CITY OF ALBUQUERQUE

RE: **Matheson Park Elementary School Site Improvements** **H21-D036**
4410 Irving Blvd. NW PE Stamp: 4/22/2013
Grade & Drain Plan for Grading, Paving and SO-19 Permits

Based upon the information provided in your submittal received 05-16-2013, the above referenced plan cannot be approved for Grading, Paving or an SO-19 Permit.

C-402

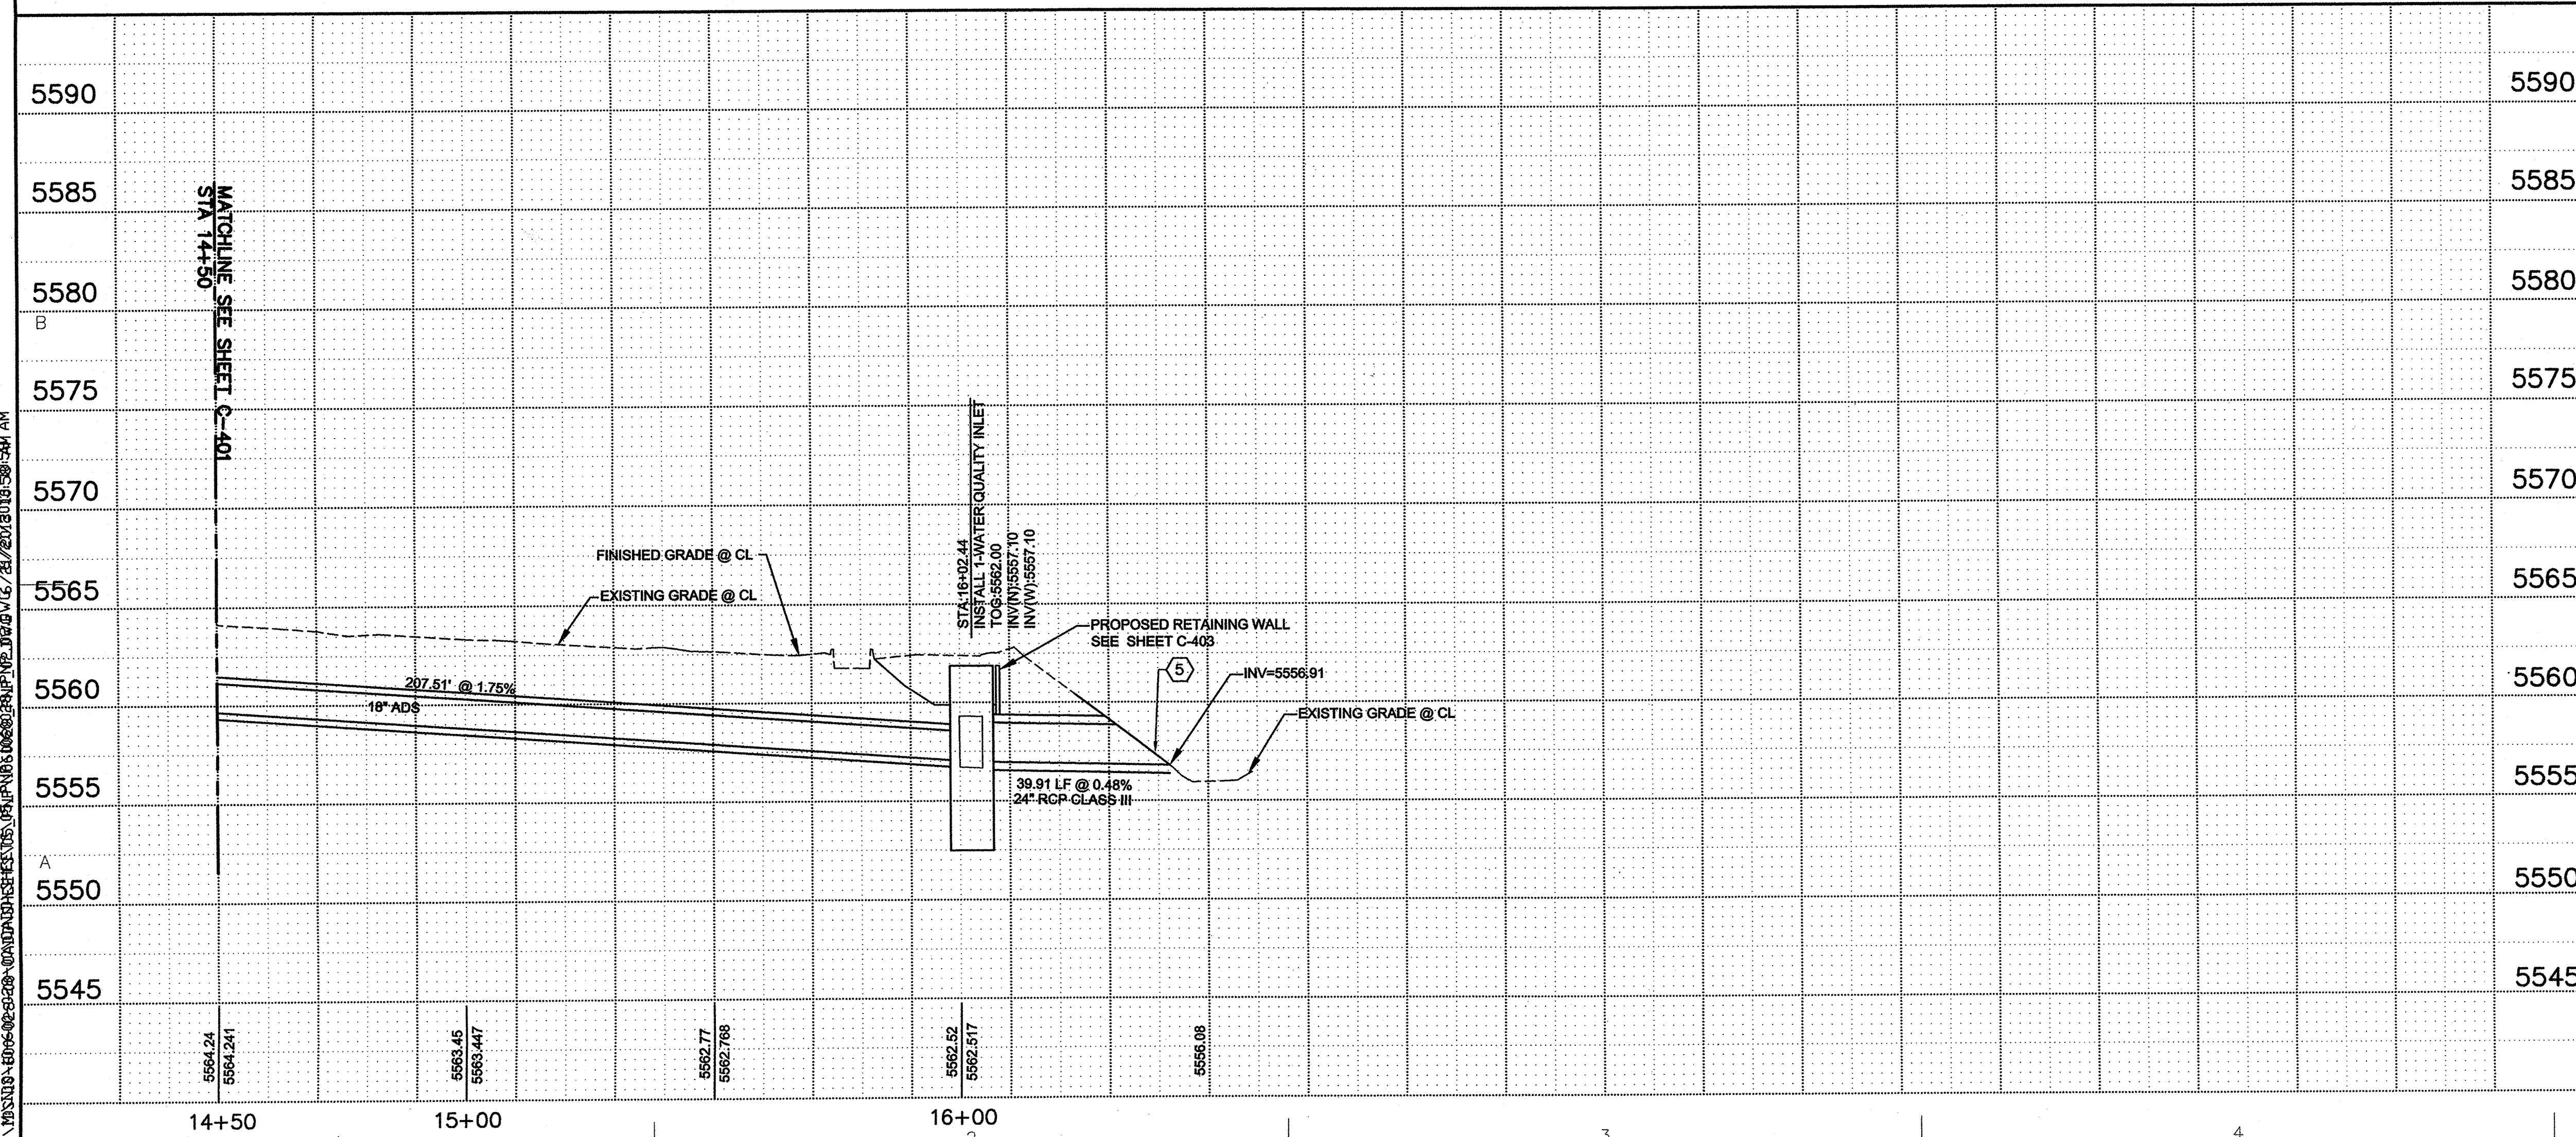
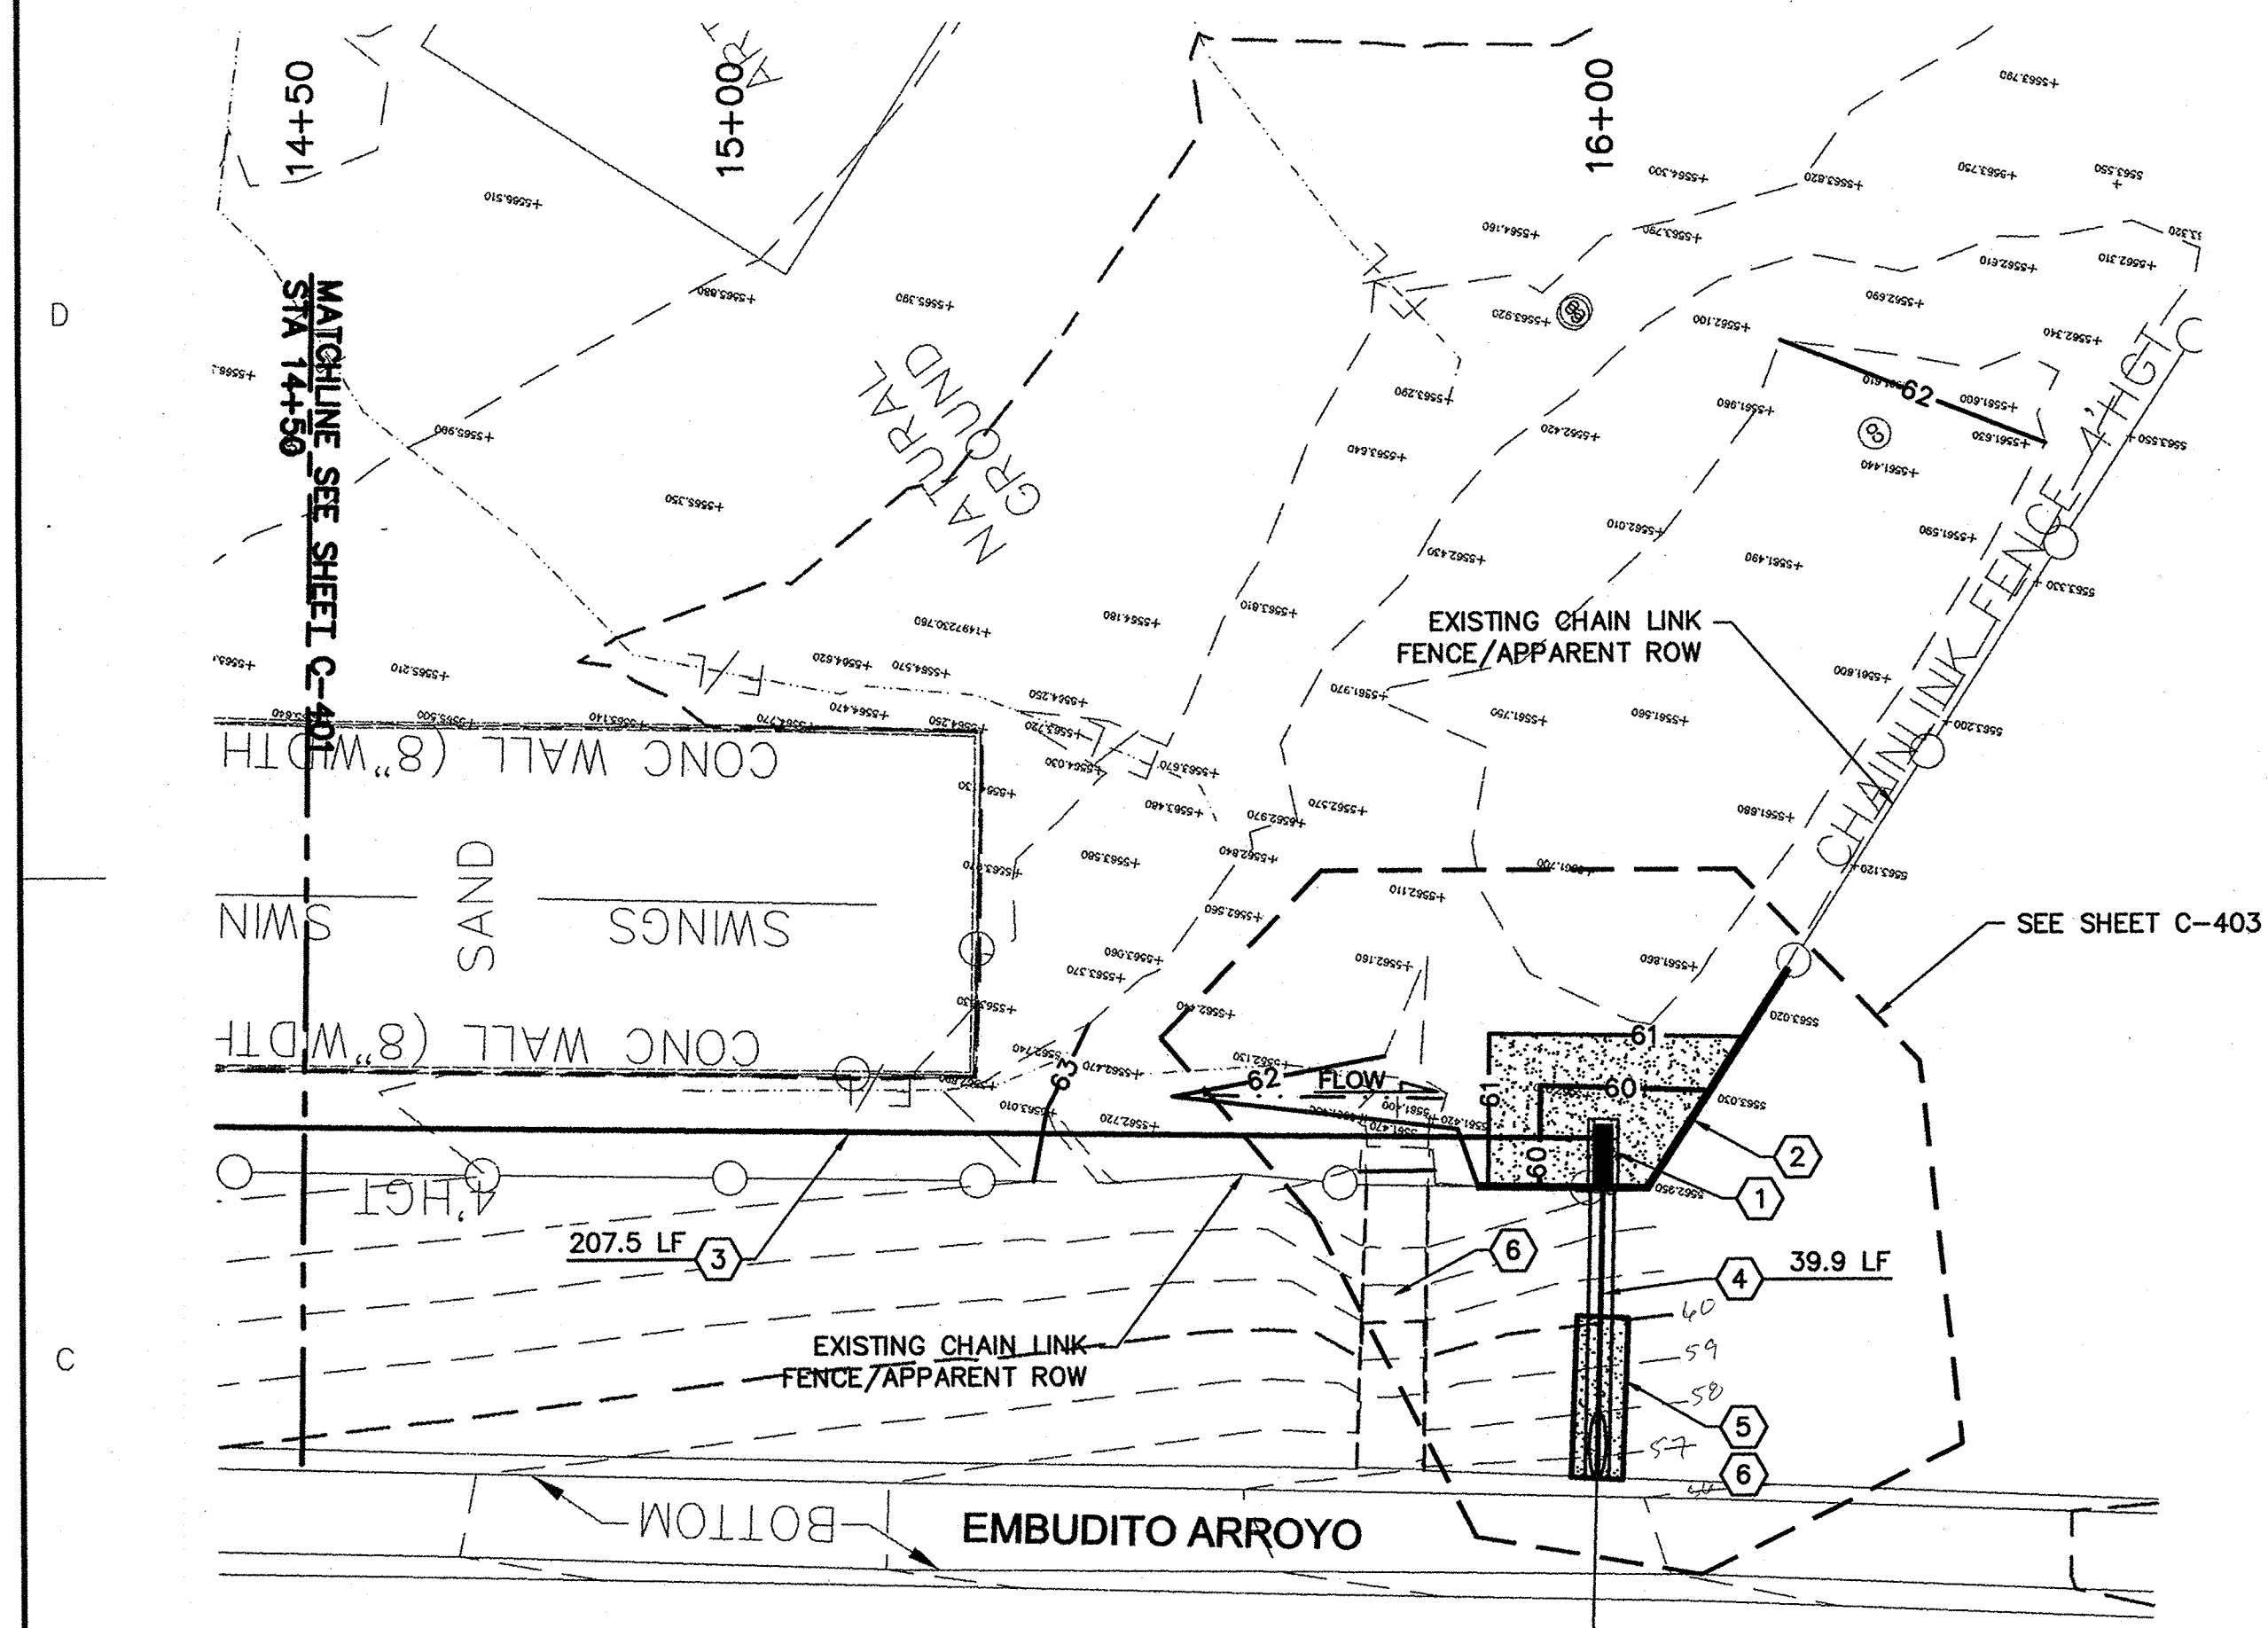
8. C-102: Label pipe line sizes and flow direction arrows on all existing and proposed storm drain piping.

15. C-102: Key Note 9 proposes a 6-ft. diameter storm drain manhole that appears to intercept the existing 18" storm line to the channel. It appears from our records that the existing line is shallower than the proposed line. Will flows in the existing line be diverted into the new system? Clarify this installation, and provide invert elevations on the existing line at the crossing/tie-in. [*Is this MH really needed, or could the new system simply cross under/over the existing, without interconnecting the flows ?*]
